Ribble Valley Borough Council
Housing & Development Control

Your ref: 3/2023/0827
Our ref: D3.2023.0827
Date: 22nd December 2023

Application no: **3/2023/0827**

Proposal: **Proposed change of use from nursery to eight flats (C3) comprising three two-bedroom units and five one-bedroom units.**

Ground Floor Plan
scale 1:100
0 1 2 3 4 5m

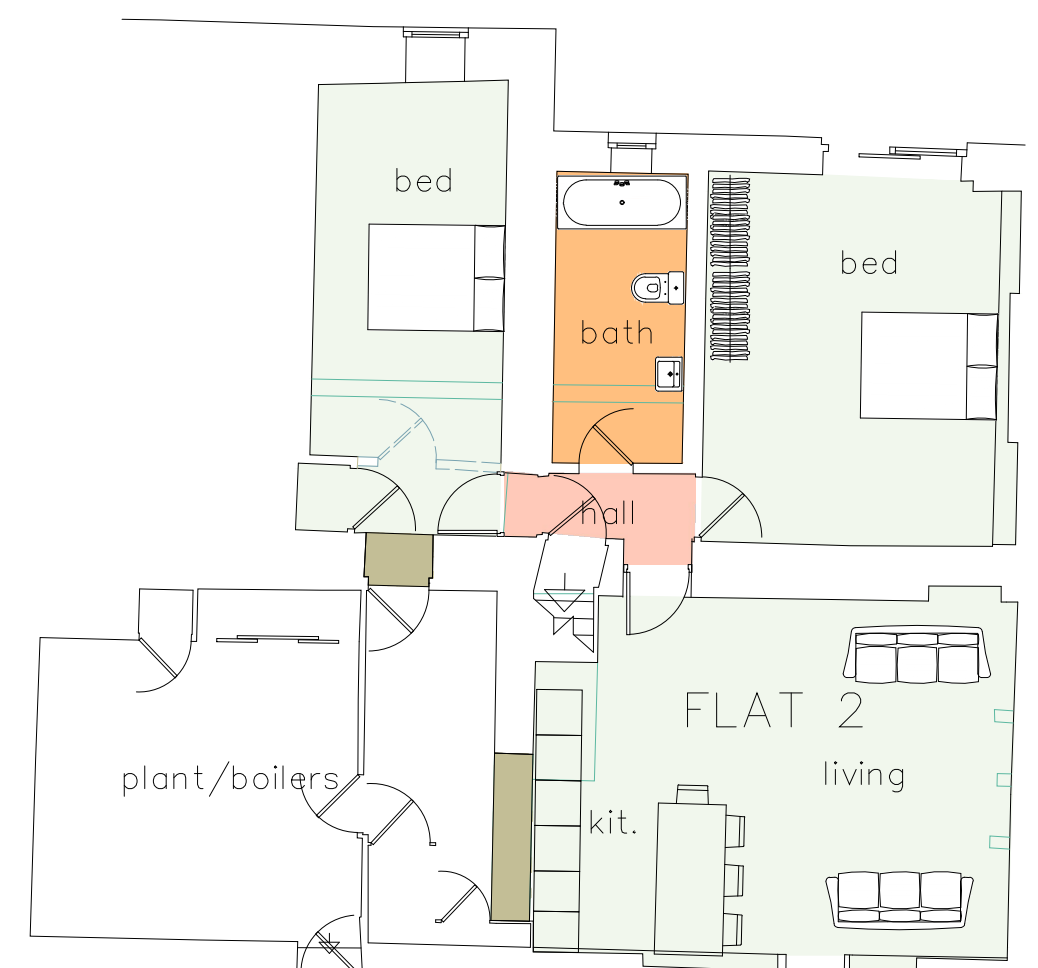
Before the LHA can support the use of the existing access to serve the site, the LHA require a swept path drawing showing that vehicles using the two car parking spaces can turn internally and exit the site in a forward gear. The LHA require this because the existing parking arrangements have changed following the proposal with the Undercroft being converted into residential accommodation for Unit 1. Therefore, the LHA are concerned that the area lacks the adequate space to enable vehicles to turn and exit the site in a forward gear.

The LHA advise that the two car parking spaces are omitted from the scheme in any case and that the area is used for servicing vehicles only. This is to prevent any internal disputes between the occupants of the site and to prevent vehicles from using the access in the hope that a car parking space is free which could lead to vehicles having to reverse onto the adopted highway.

To ensure that the area is suitable for servicing vehicles, a swept path drawing is required showing that a servicing vehicle can turn internally and exit the site in a forward gear. Should the swept path show that there isn't adequate space to undertake this movement, the LHA will request that the Undercroft remains as existing to aid these movements.

Drawing Title			
PROPOSED SITE PLAN (WITH TOPO)			
Job/Reference Number		Drawing Number	
0704/93		Drawing No 20	
Scale	Date	Drawn	Checked
1/100	Sept 23	a.t.l-h.

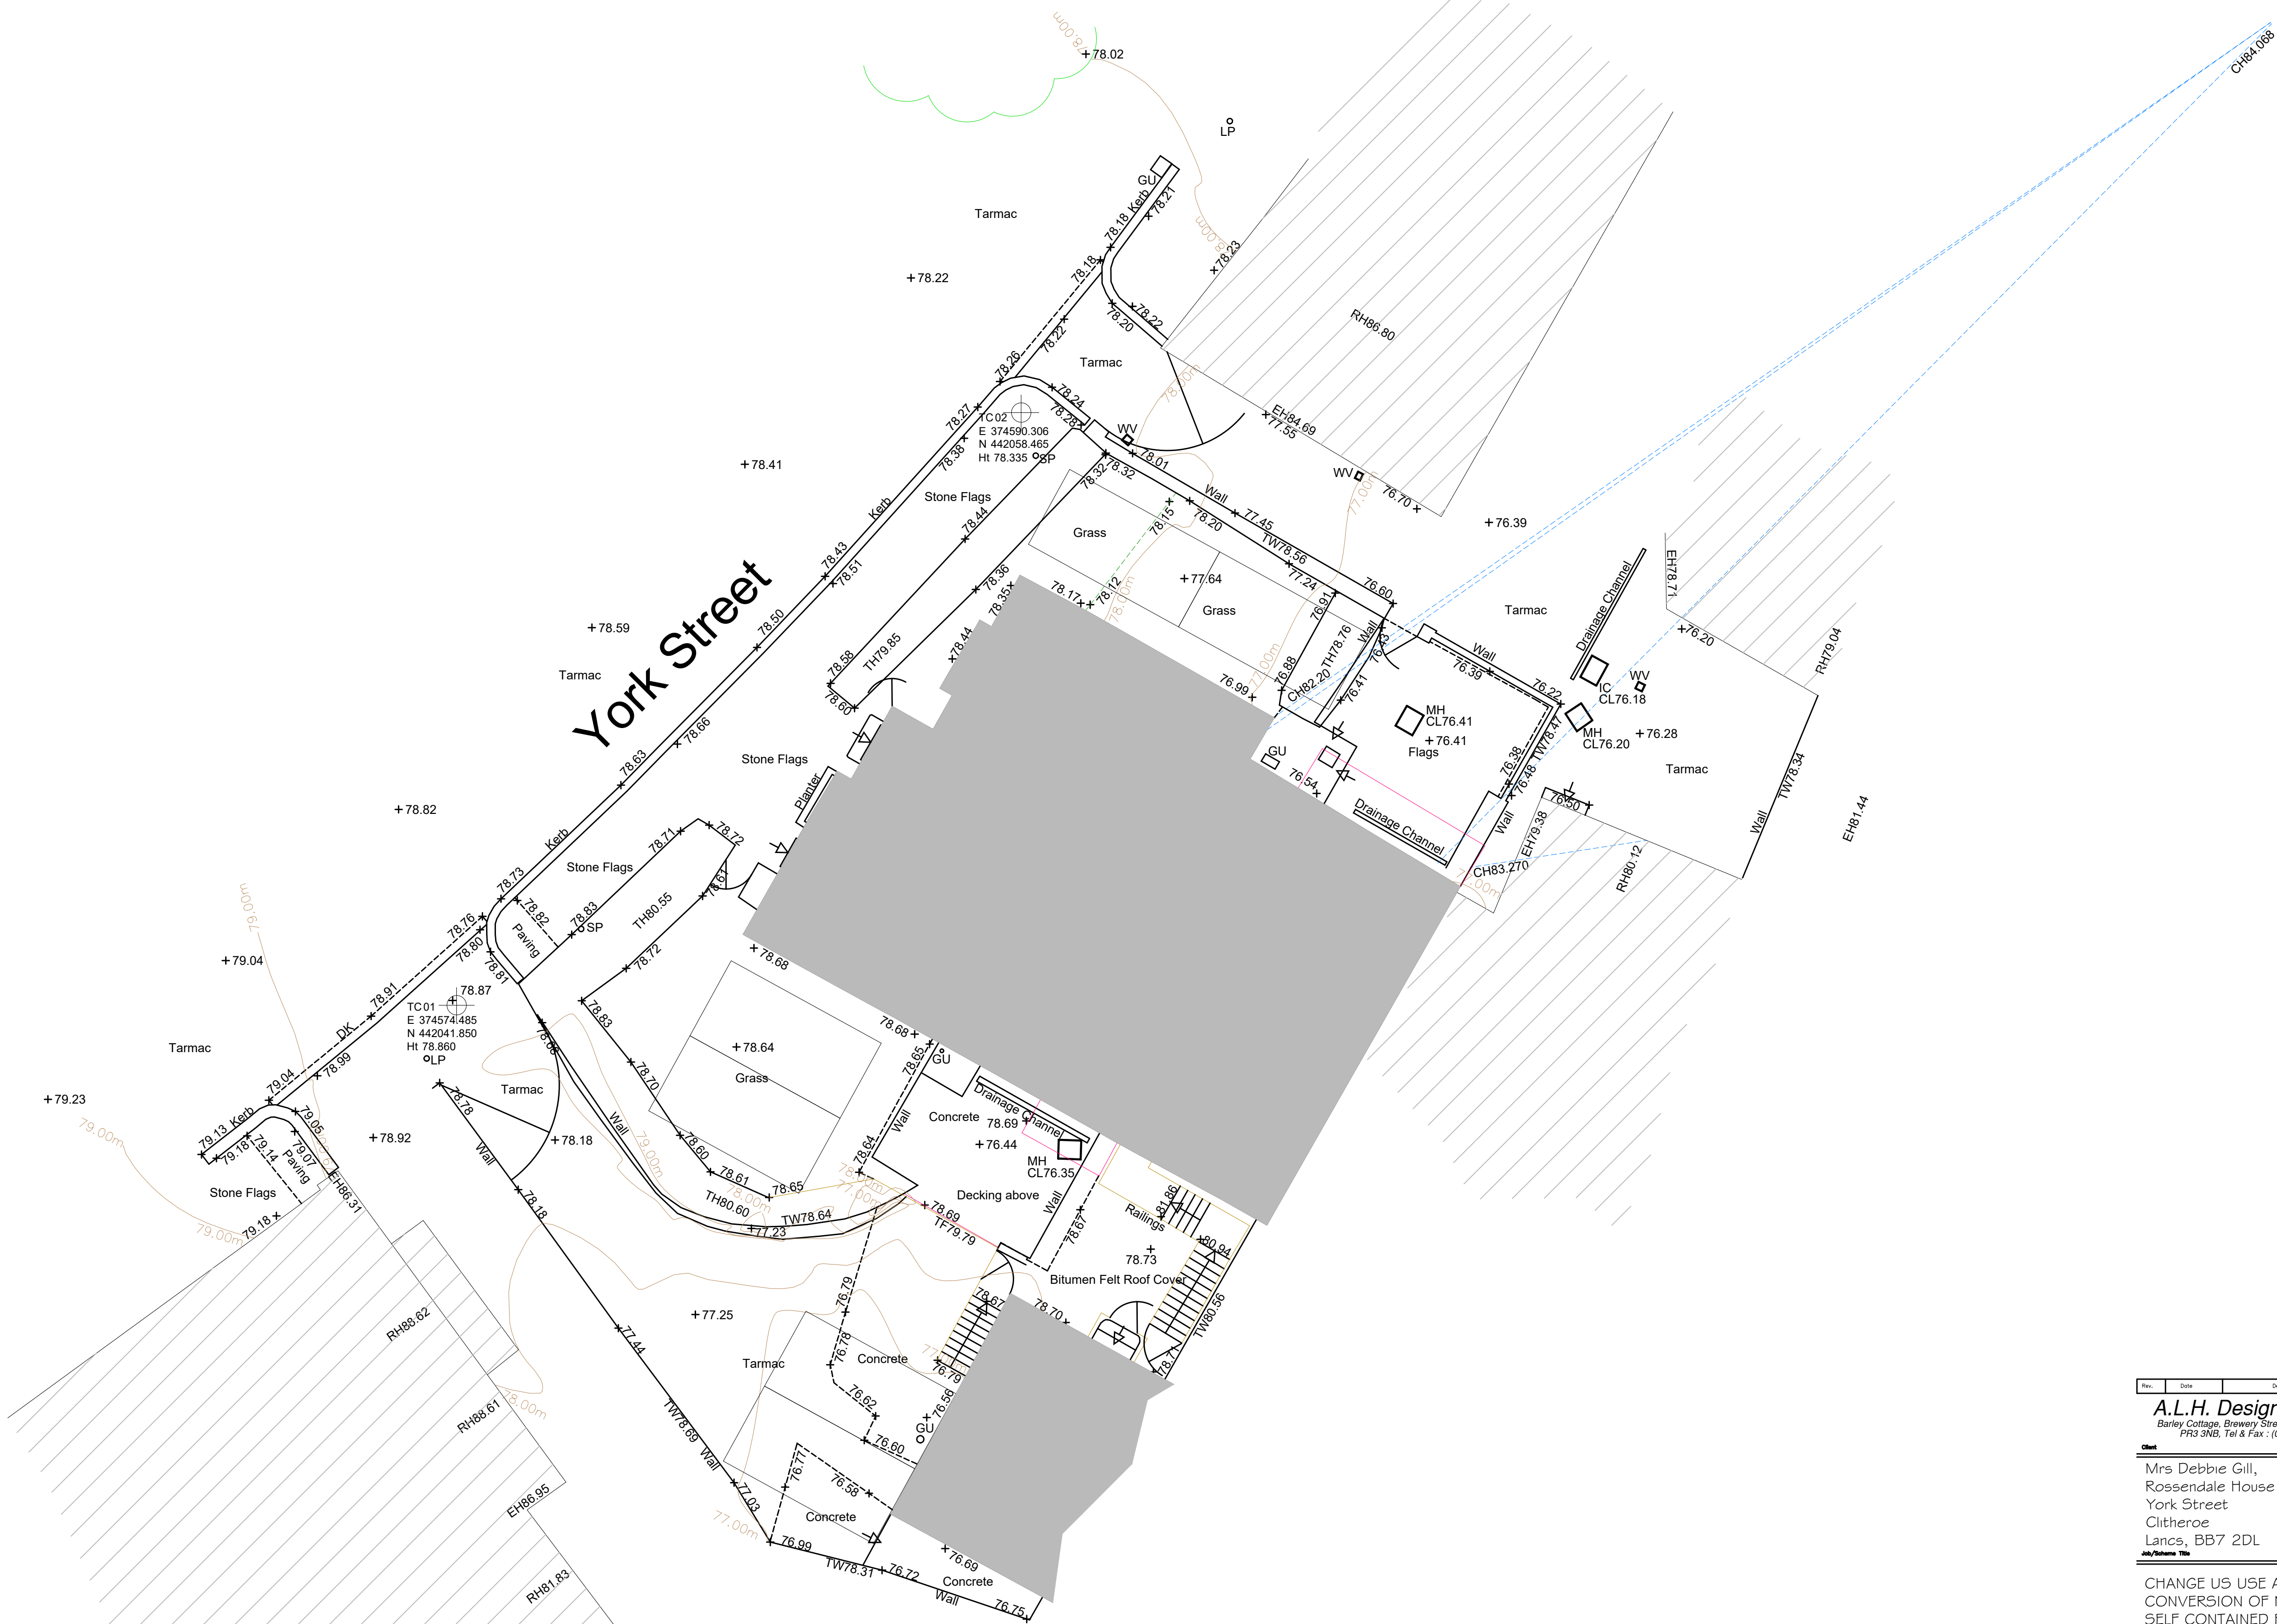
Following the proposal, as shown on ALH drawing number 09 titled "Proposed Site Plan," the site will continue to use the existing access and a further two accesses will be created, all serving two car parking spaces each.

However, the LHA are unable to support the creation of two new accesses within this location. This is because the two parking areas will not provide any internal turning areas to enable a vehicle to exit the site in a forward gear. The LHA require a parking area located off a classified road to provide an internal turning area due to the expected high traffic flows and given the central location of the site, high pedestrian movements. The accesses are also too close together and too close to already established site accesses. Therefore, the LHA require the new parking areas to be omitted from the scheme.

The LHA require a shared bin storage and collection point to be located in close proximity to the adopted highway. The LHA suggest that the area located in between the pedestrian access to the building and the existing access is used as the shared bin designated area. This is because it will be easier for refuse operatives to access the bins during collection day and occupants will not need to move them. Therefore, an amended plan is required showing where this will be located.

- An amended plan showing that the two new parking areas are omitted from the scheme.
- A swept path drawing showing that a servicing vehicle can enter and exit the existing access in a forward gear.
- Location of a bin storage and collection point.
